Please ask for: Nicola Moore
Email: nicola.moore@arun.gov.uk
Telephone: Ext 37944
Our Ref: Y/150/21/HH
Your Ref:
Date: 15th October 2021

Application for Planning Permission for Works or Extension to a Dwelling

Development: Detached single storey home office/garden building in rear garden.
Location: 15 Kings Close Yapton BN18 0EX

South View

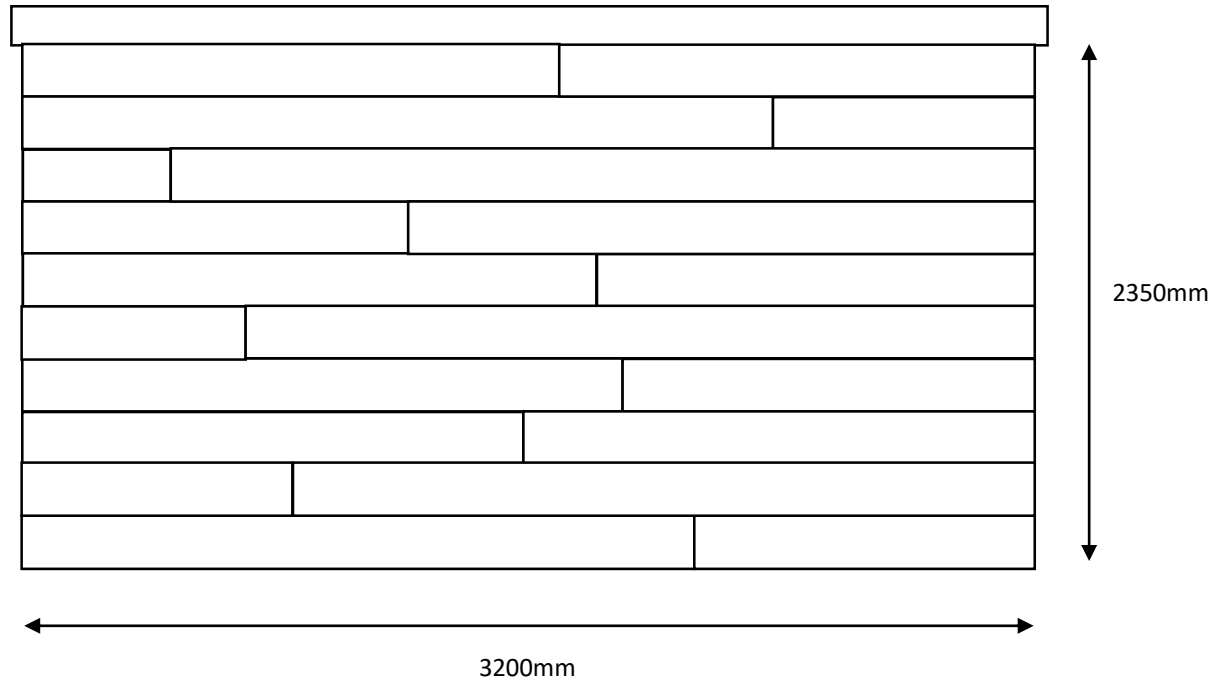
Please amend the Floor Plan and South View plans to include the door dimensions and re submit.
